Project Name: Lot 2, Blackwood Crossing Filing 1A (AR DP 17-00765-A1MJ21)  
Review Number: 2

Thank you for your recent comments on 02/18/2022 regarding the Development Plan submittal for Lot 2, Blackwood Crossing Filing 1A. We have prepared the following responses which address those comments and have included the necessary resubmittals in PDF format. Please feel free to call us with any questions or concerns.

SHEET NO.
C01

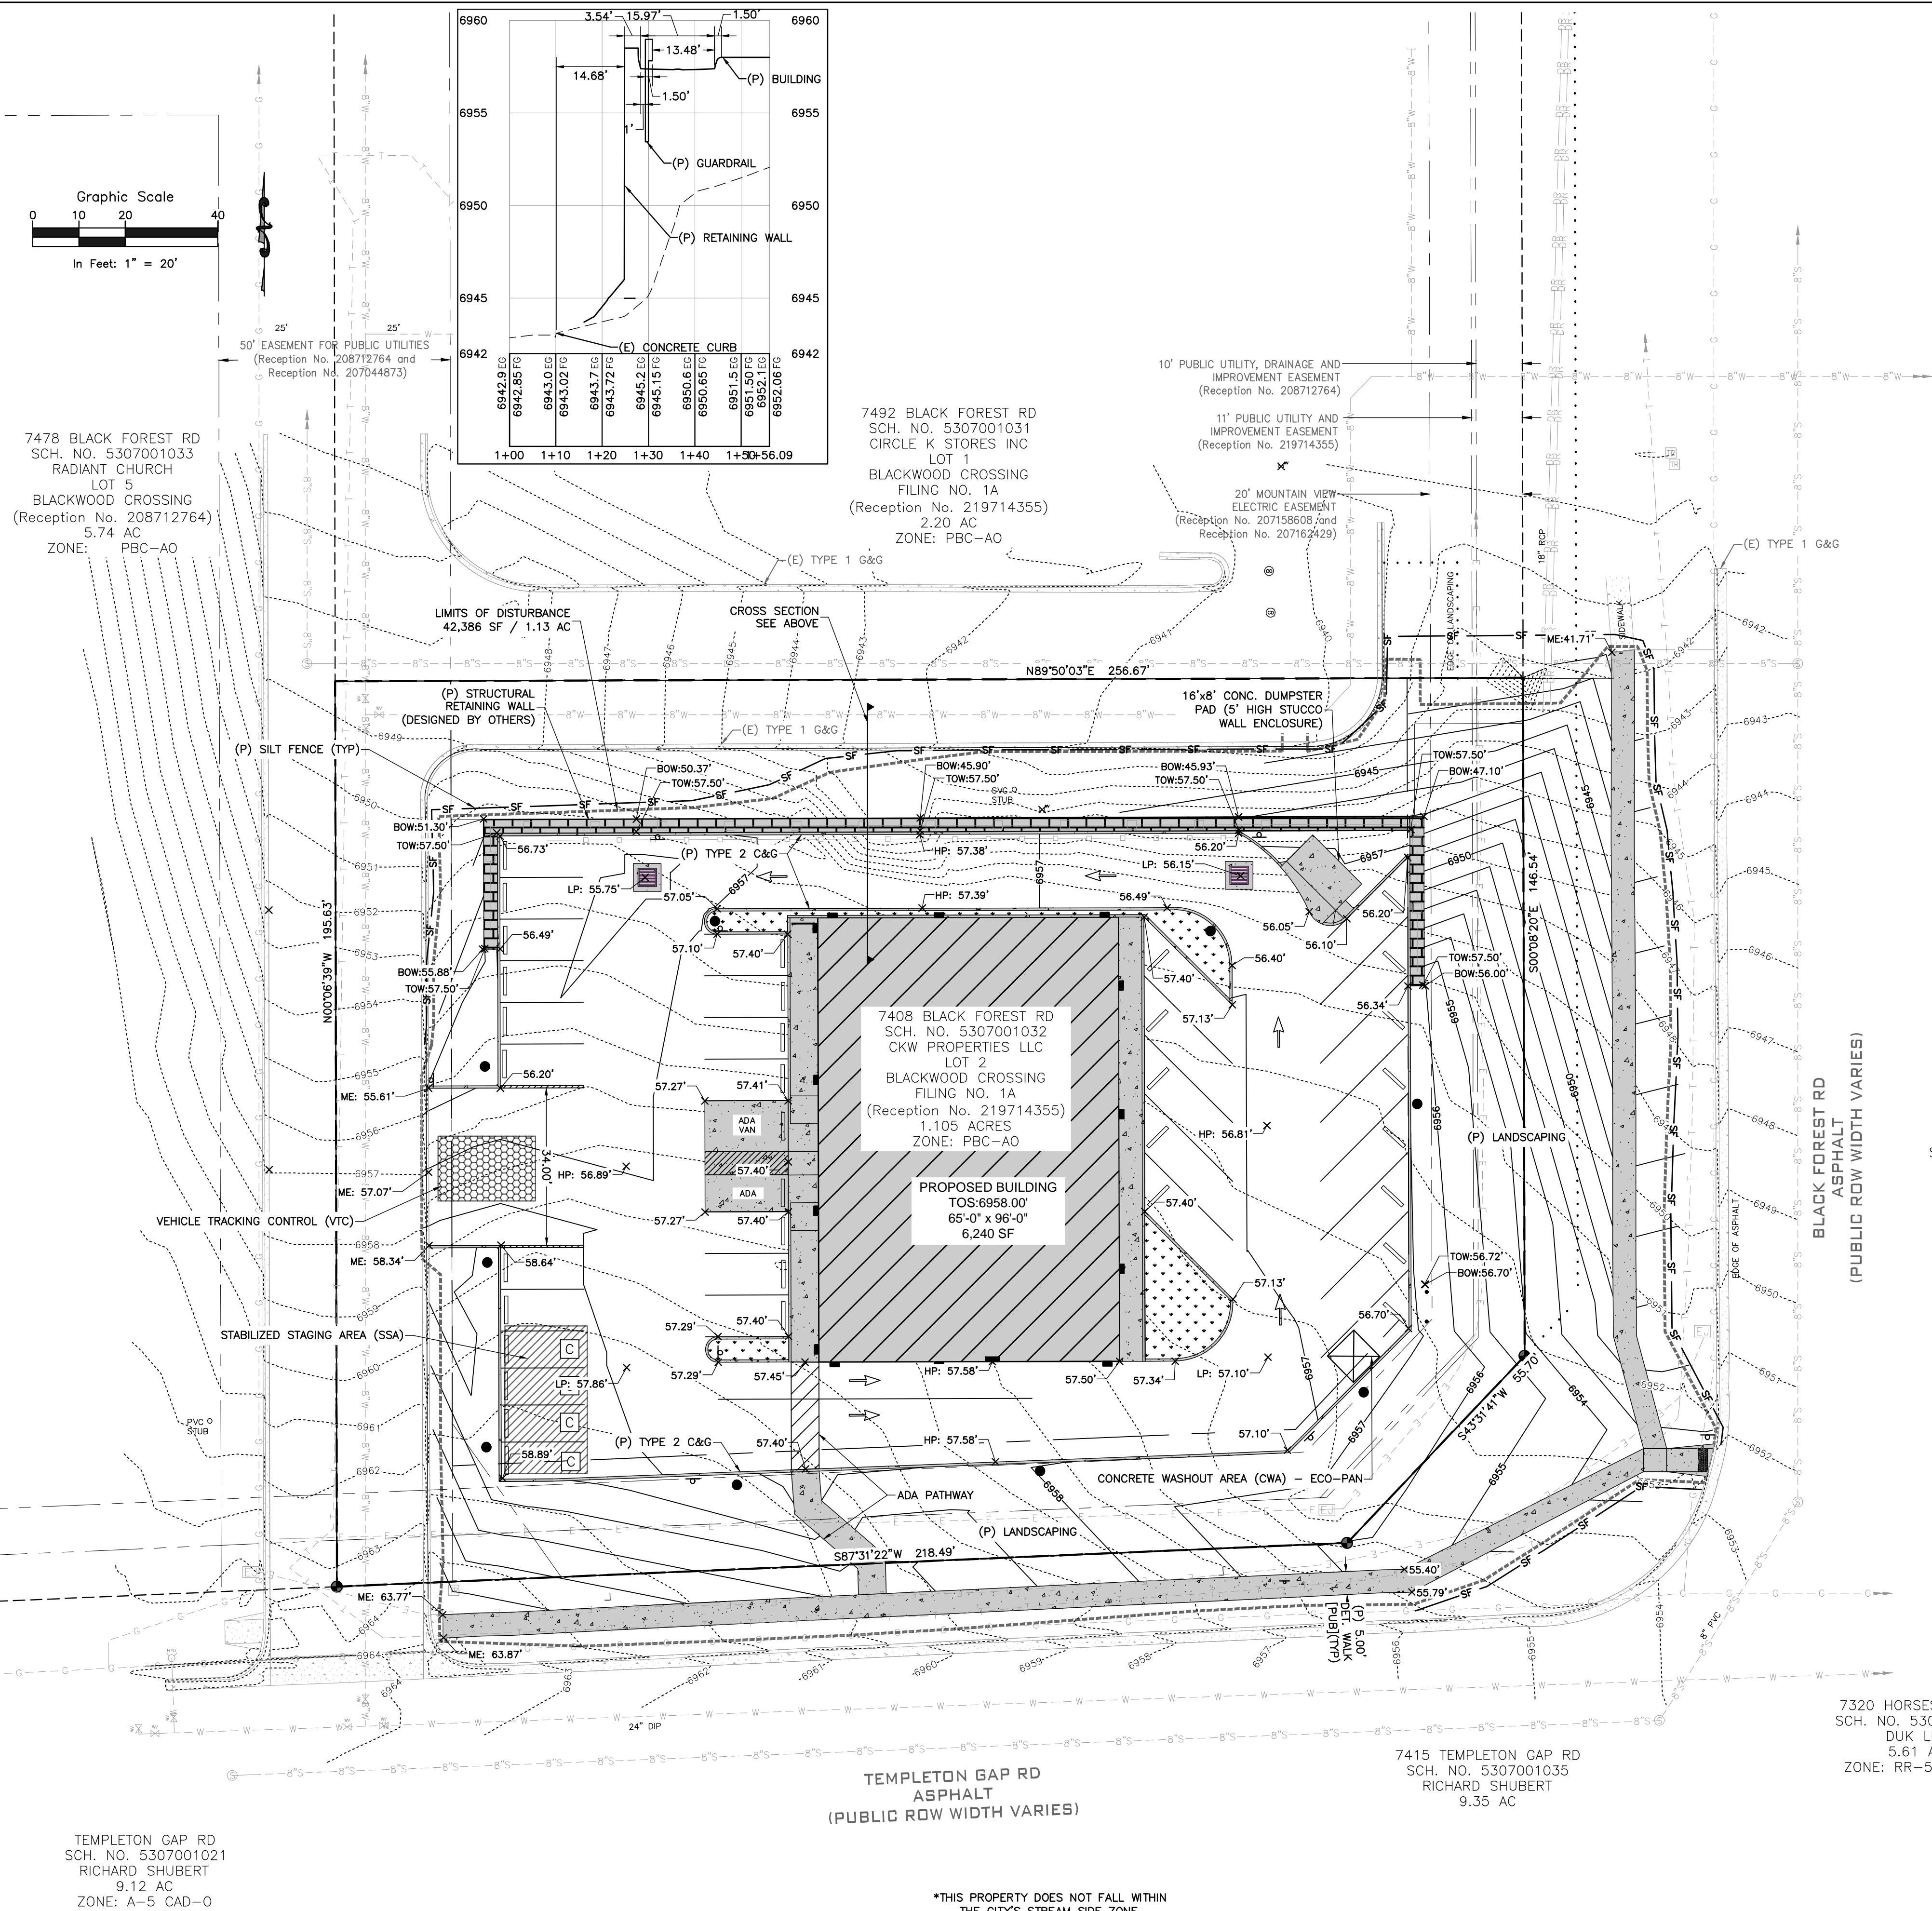
1. Cover Sheet – add or correct the following to the site data on sheet one of the plan:
  - A. Include a note describing the project’s inclusion in Woodmen Heights Metropolitan District 3 and the Woodmen Road Metropolitan District
    - i. Please include Woodmen Heights Metropolitan District 3 in note 15 as well and indicate City Ordinance numbers as indicated in the response letter

1. Previous comment 1, partially addressed: Please revise the area under the property description on sheet C01 (1.105 acres platted) (339,524 square feet being 7.79 acres more or less shown under property description).

1. Add note stating who owns and maintains the detention facility that provides full spectrum detention for this site.

**Response: This note has been added to the cover.**

**Response: All places where the site area has been mentioned now read as 1.105 acres.**

**Response: This note has been added.**

C04

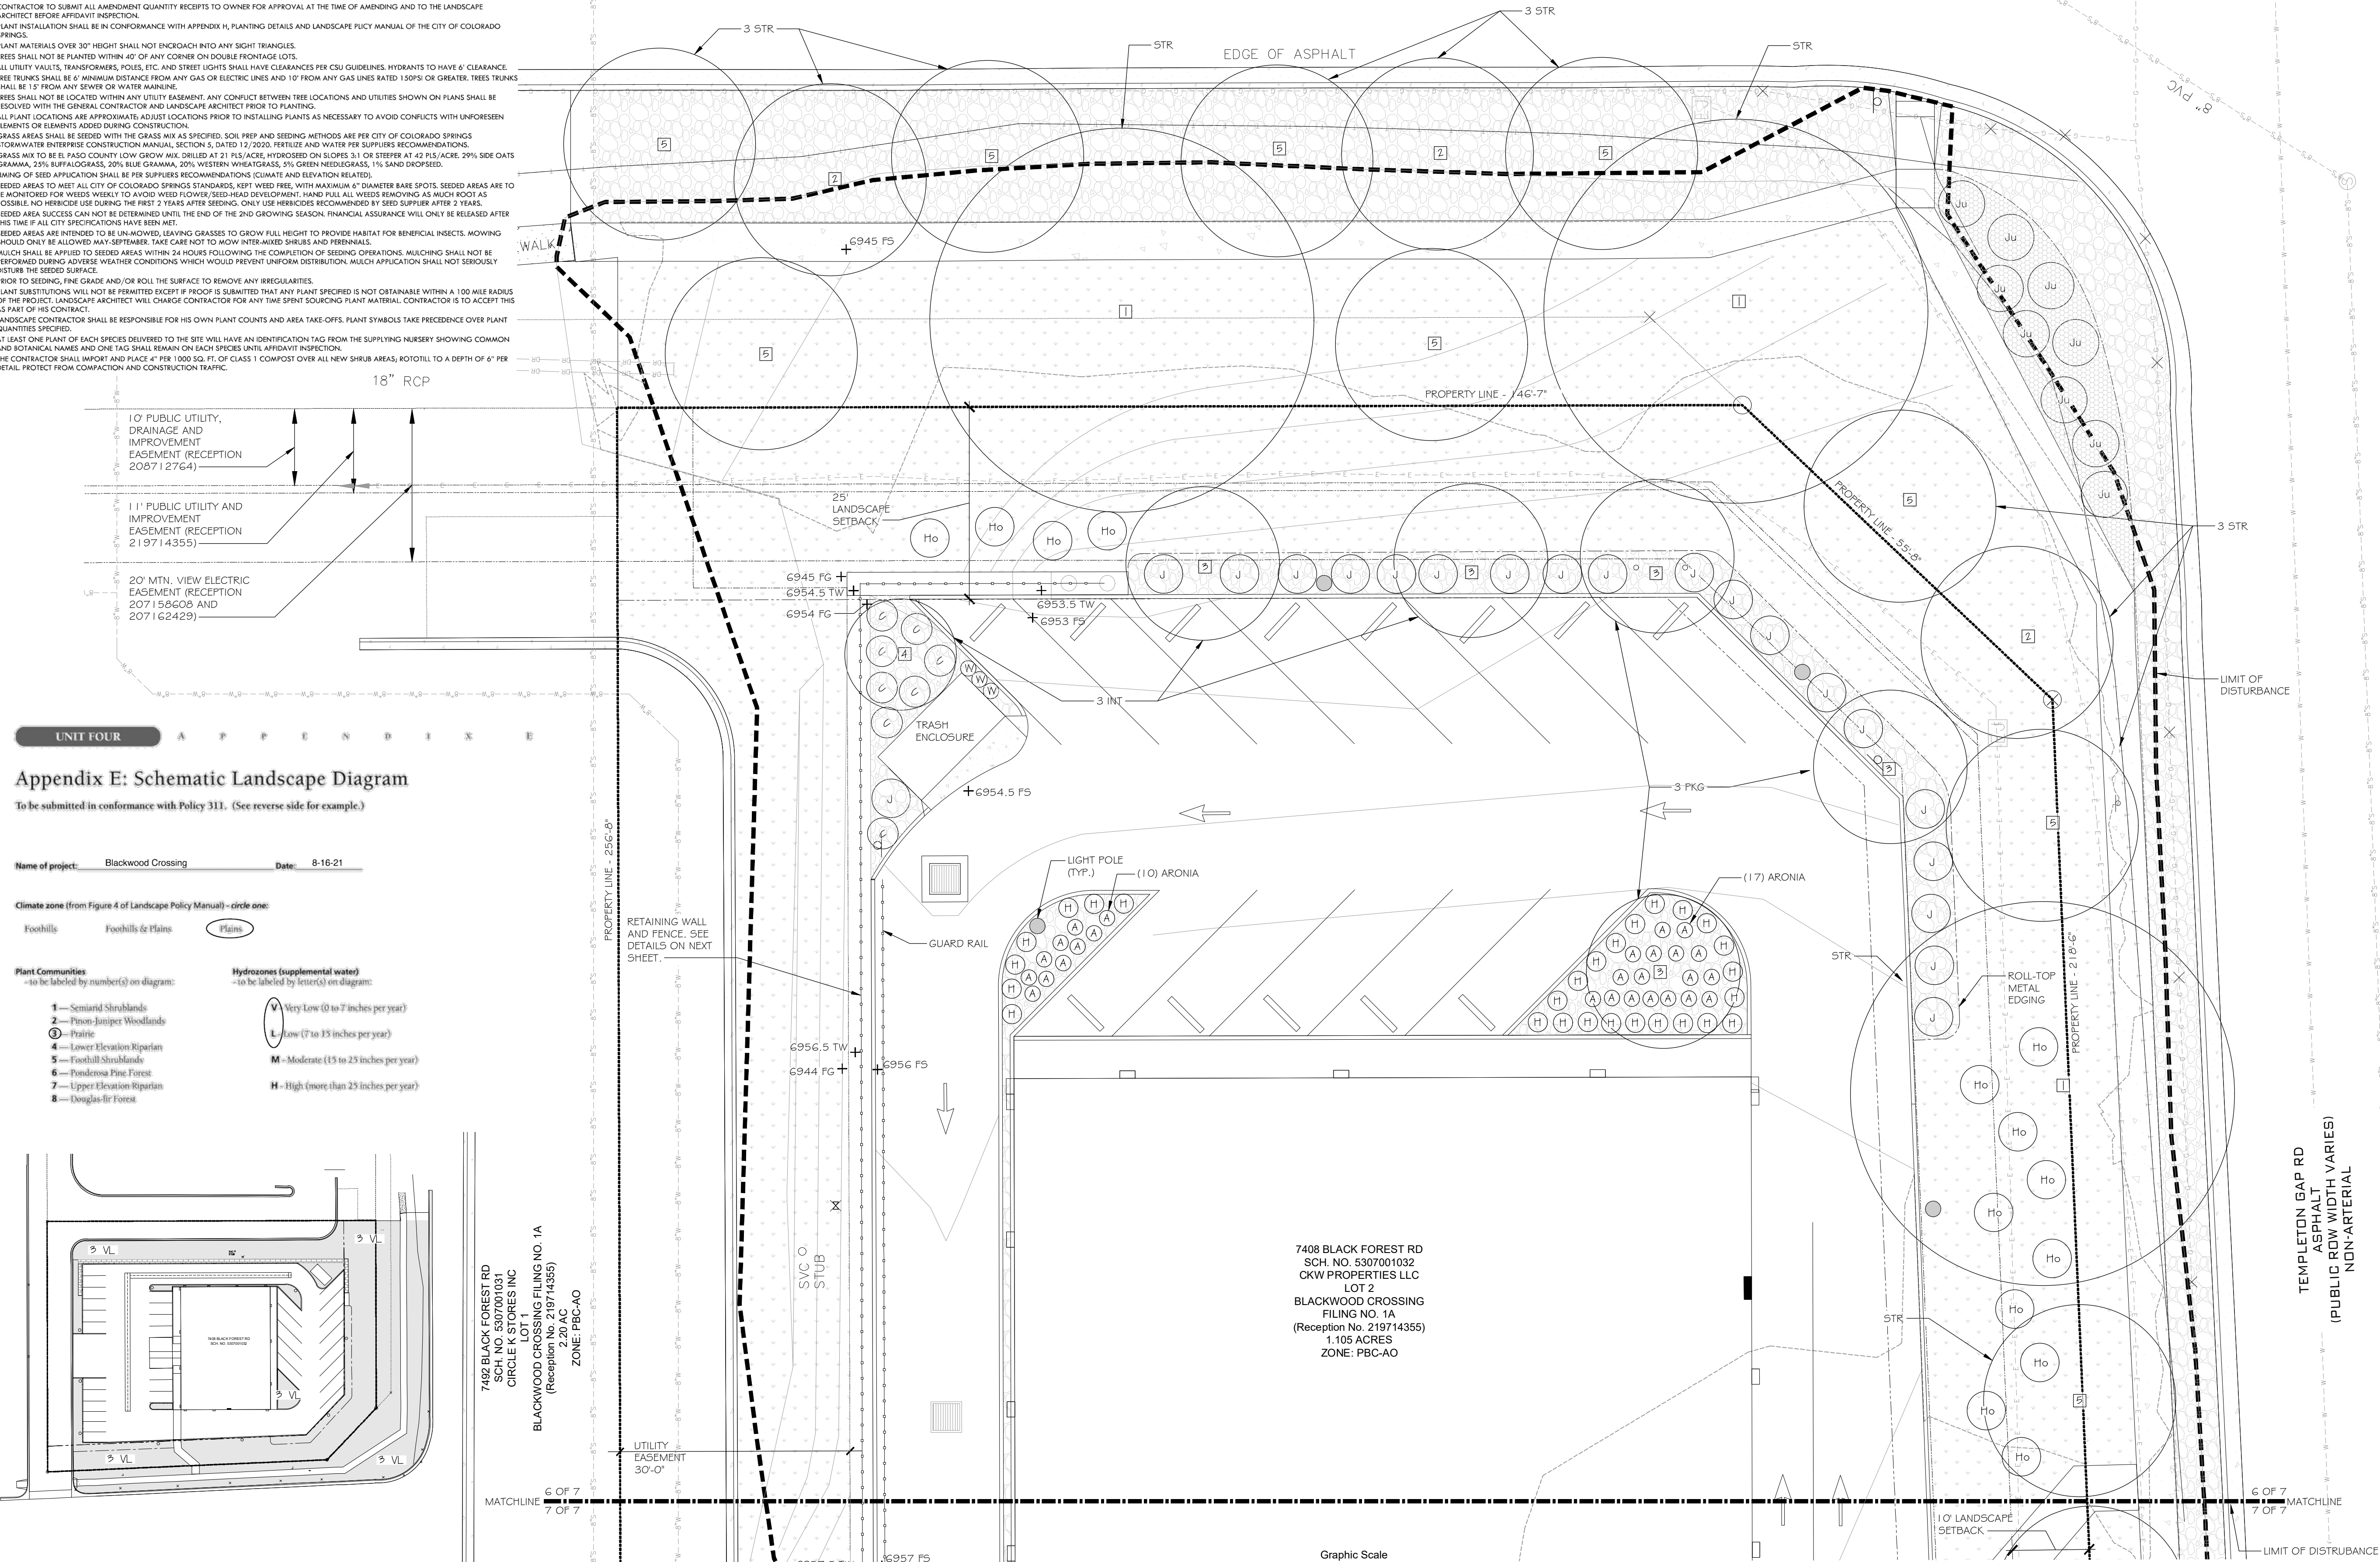
2. Show stormpipes with size, type and ownership.

3. There is an area in the Ne corner that does not appear to drain to inlets. Please resolve.

4. Label the stub in Black forest you are connecting to.

5. Pipe will be private on property and public in the ROW. Please better show that.

**Response: These have been labeled.**

**Response: This area has been revised.**

**Response: This has been labeled.**

**Response: This has been revised.**
